**Date:** 04/16/2025

**Re:** **Damaged Roof Truss**  
Location: Lot 114 Providence Creek (312 Providence Creek Dr. Fuquay-Varina, NC)  
JDS Project No.: RDU2503974  
Date of Inspection: 04/16/25

ROOF

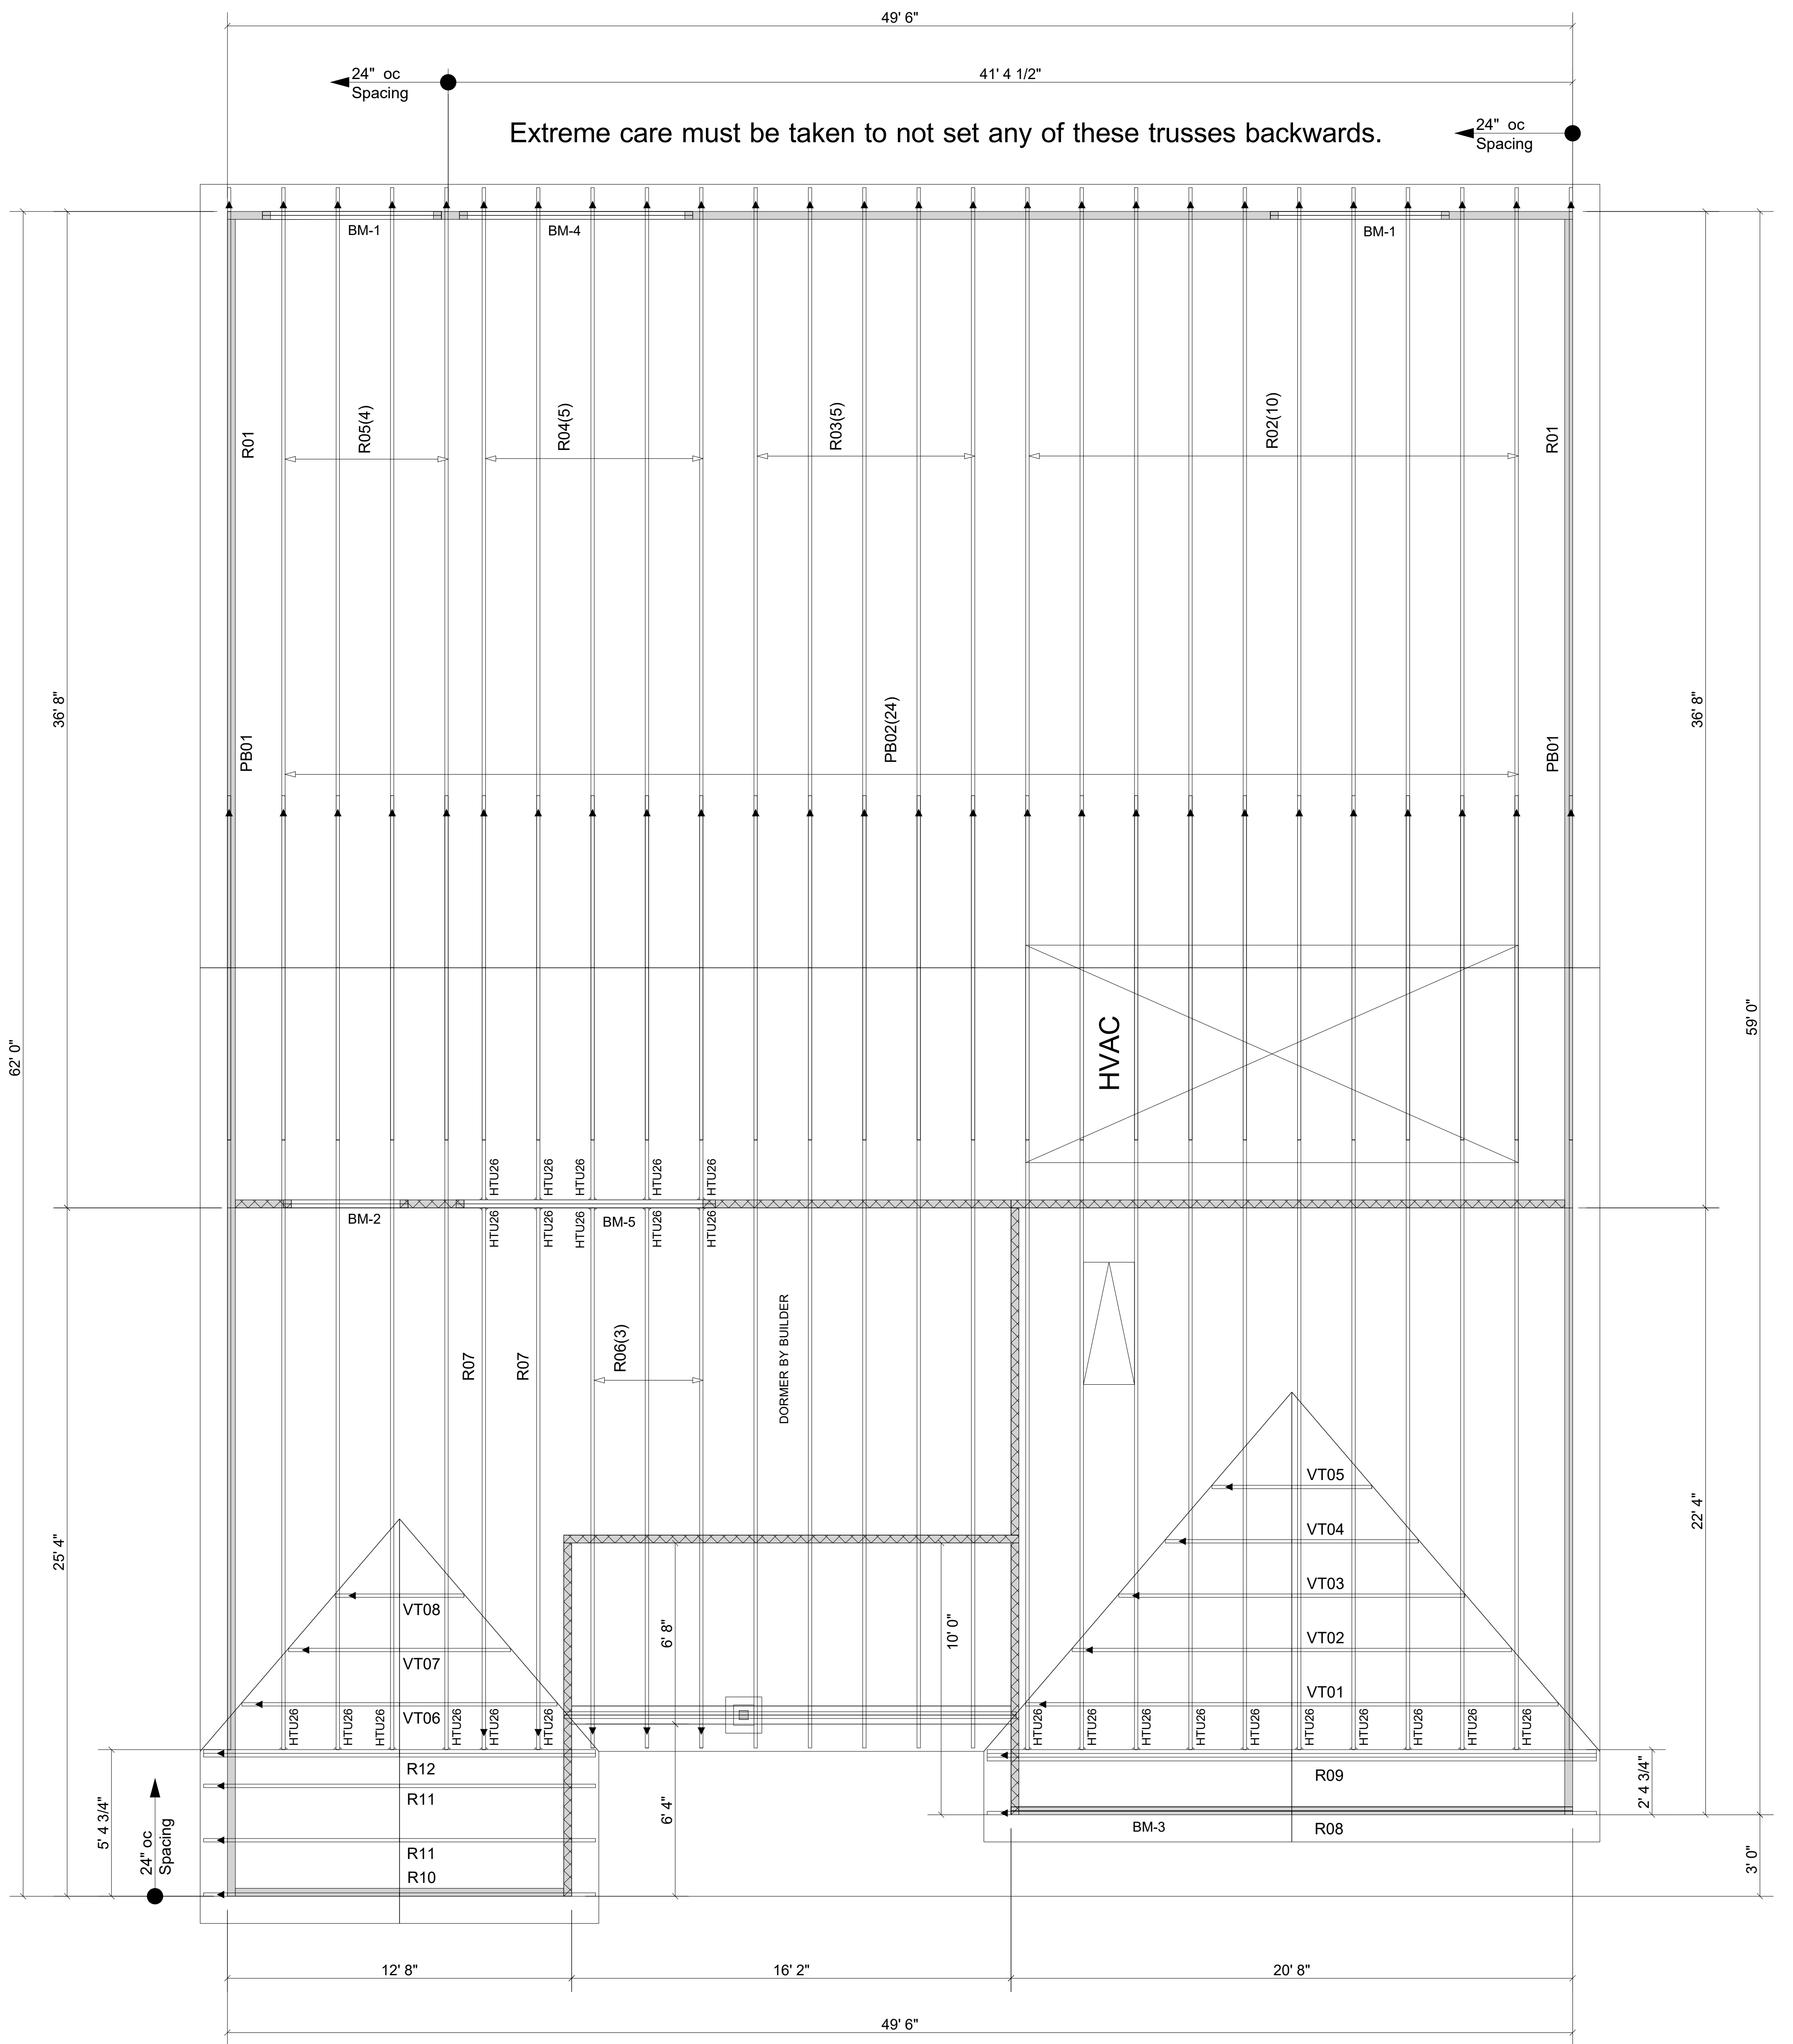
The client requests an evaluation of the 1<sup>st</sup> roof truss from the right exterior wall. The 4<sup>th</sup> diagonal web from the rear is broken.

1. Cleanly cut both ends of the broken web member flush with the gusset plates.
2. Install a new full length 2x4 web member between the existing gusset plates.
3. Install 16"x16"x7/16" OSB gussets to both sides and at both ends, centered on the existing gusset plates. Attach with (2) rows of 6d nails spaced 3" o.c. into all covered members.
